WEST SUSSEX COUNTY COUNCIL CONSULTATION

TO:	Arun District Council FAO: Harry Chalk
FROM:	Highways, WSCC
DATE:	17/09/2025
LOCATION:	Strawberry Field, Courtwick Lane, Littlehampton, BN17 7PD
SUBJECT:	LU/163/25/PL Amendment to LU/59/25/PL to allow for the formation of overspill car park, rationalisation of existing car park and formation of residents garden including fence panels (resubmission following LU/310/24/PL). This application may affect the setting of listed buildings and is in CIL Zone 2 (Zero Rated) as other development.
DATE OF SITE VISIT:	N/A
RECOMMENDATION:	Advice
S106 CONTRIBUTION TOTAL:	N/A

DRAWING TITLE:
101 - P1 - PROPOSED SITE PLAN
PROJECT NO: **24890** DATE: **DEC 24** SCALE: **1:500 @ A3**

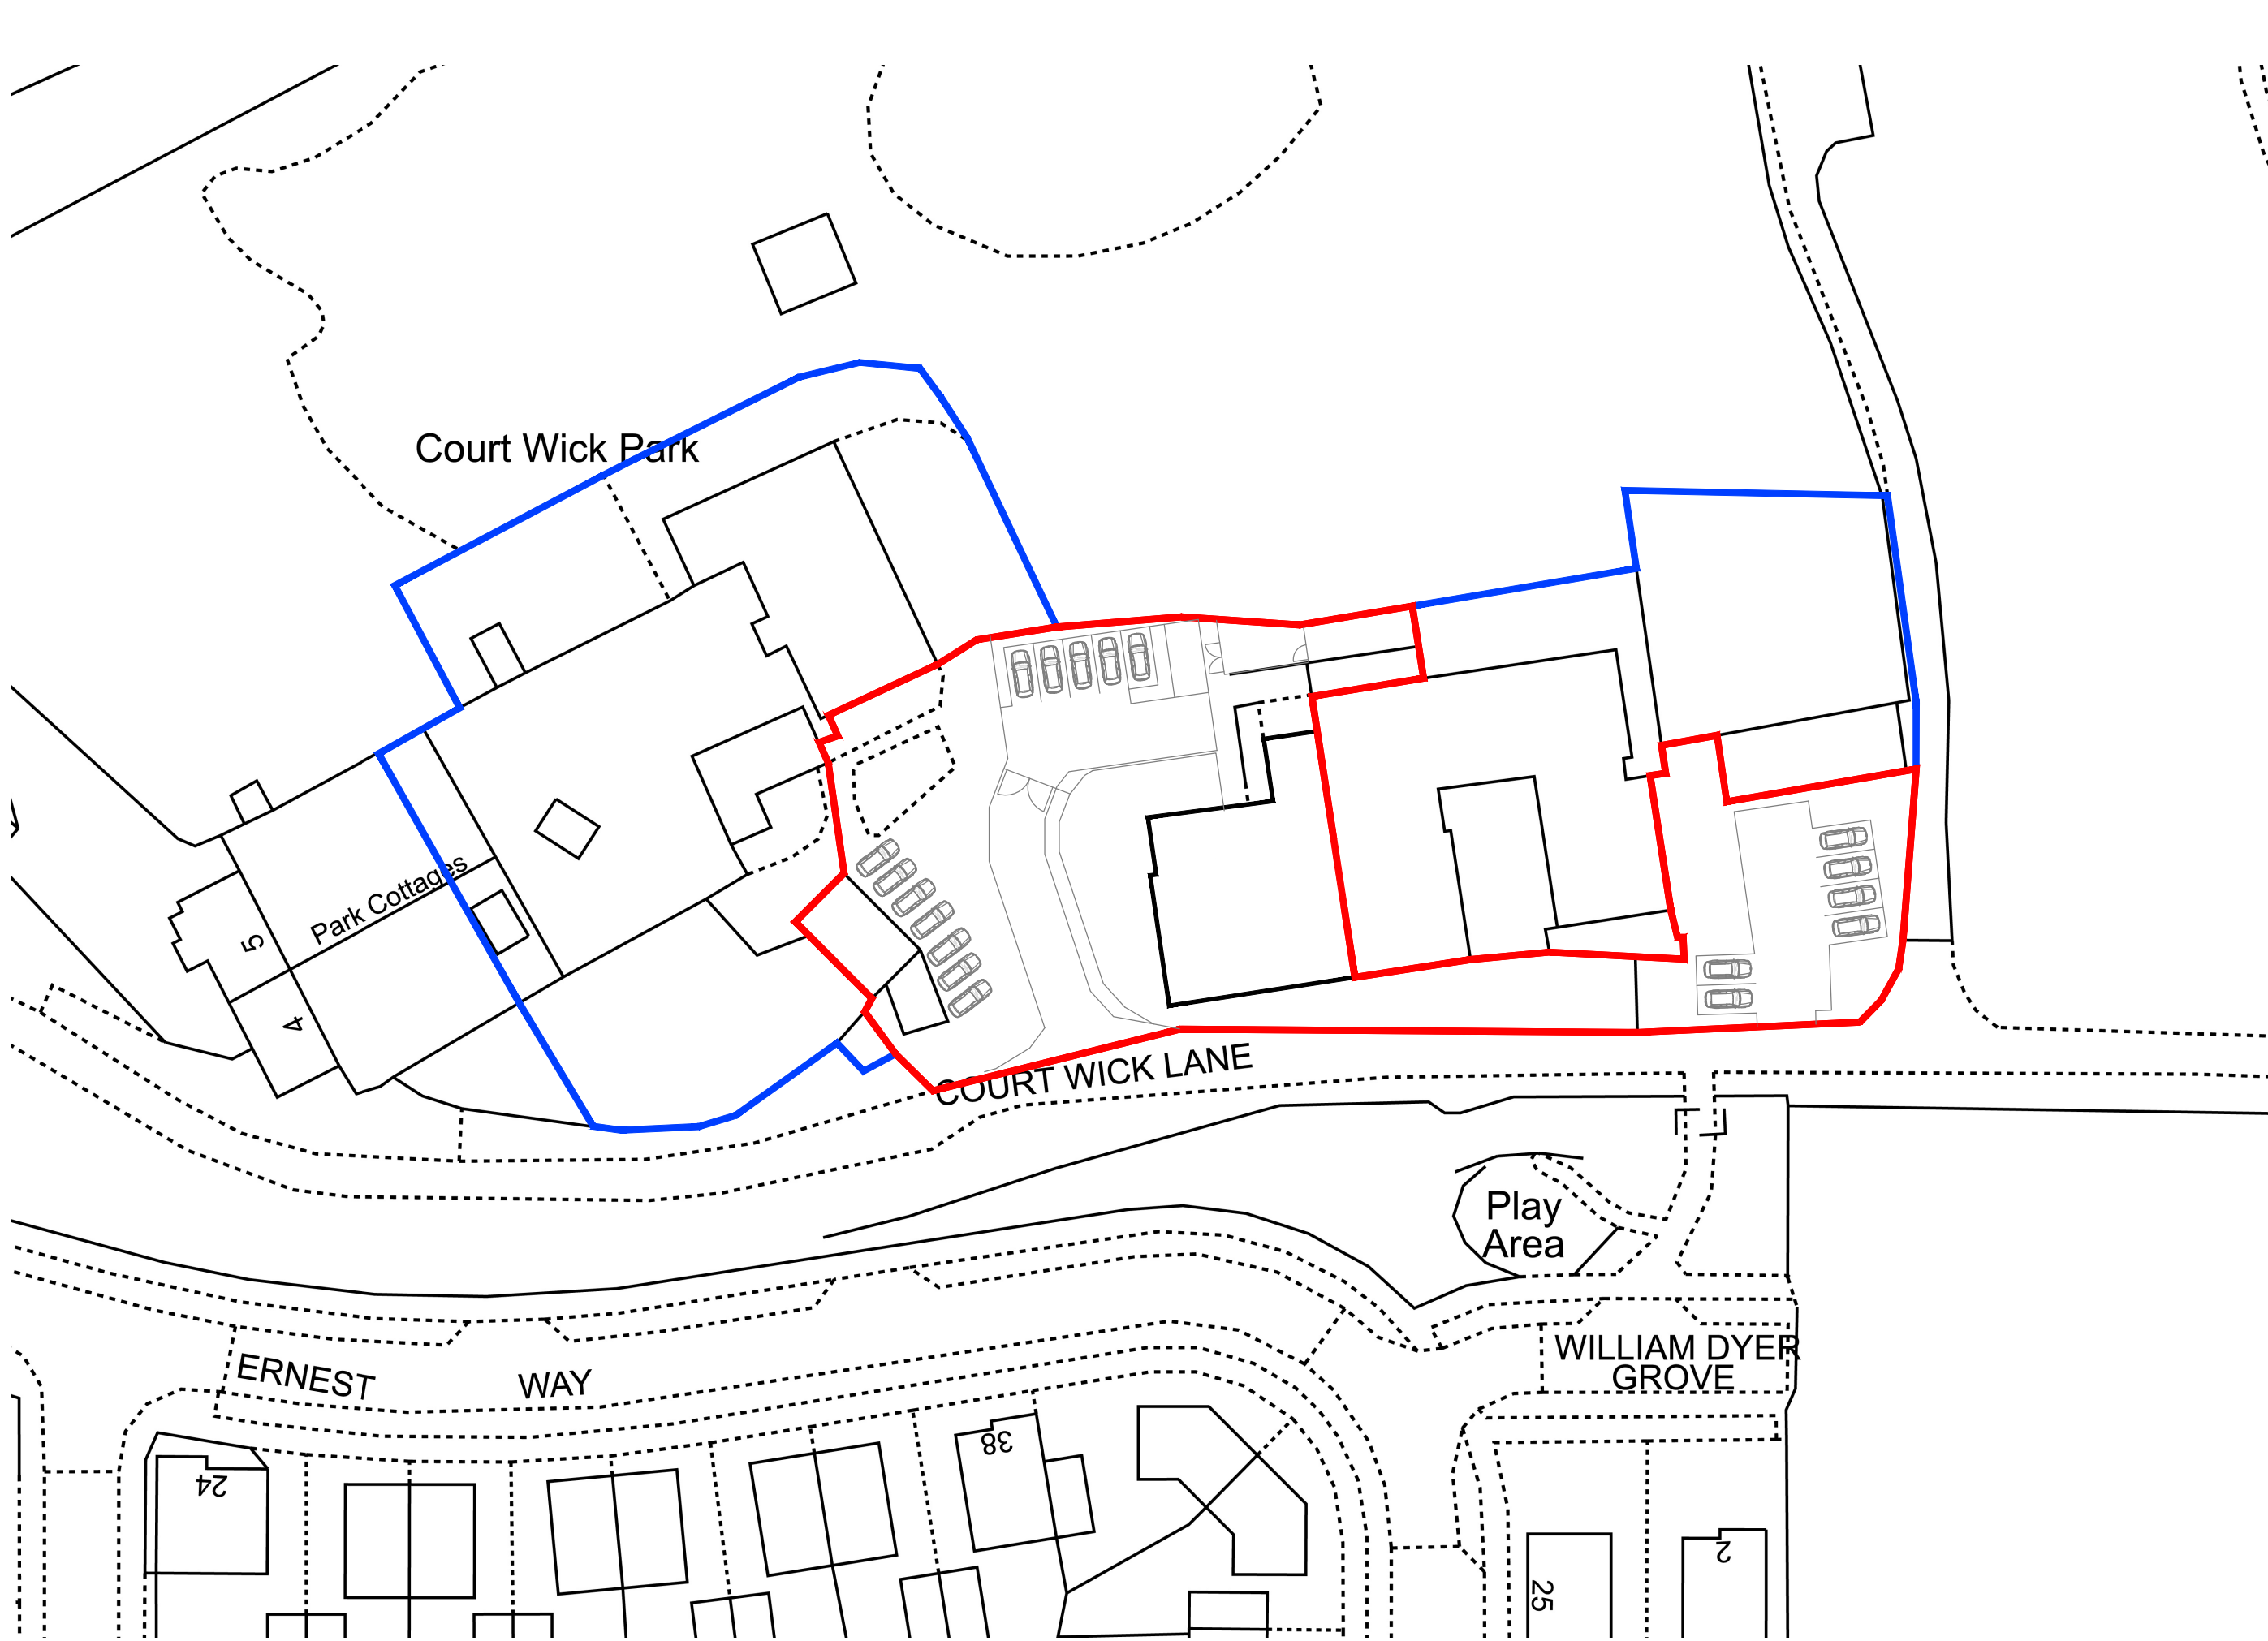
A new vehicular access point is proposed on Courtwick Lane to facilitate access to the proposed overspill car park. As Courtwick Lane is privately maintained, the applicant will be required to obtain formal approval from the road's proprietor to carry out the proposed access works.

From inspection of the plans, the proposed parking spaces for both the existing and proposed parking areas appear suitably sized and on-site turning appears achievable for both also.
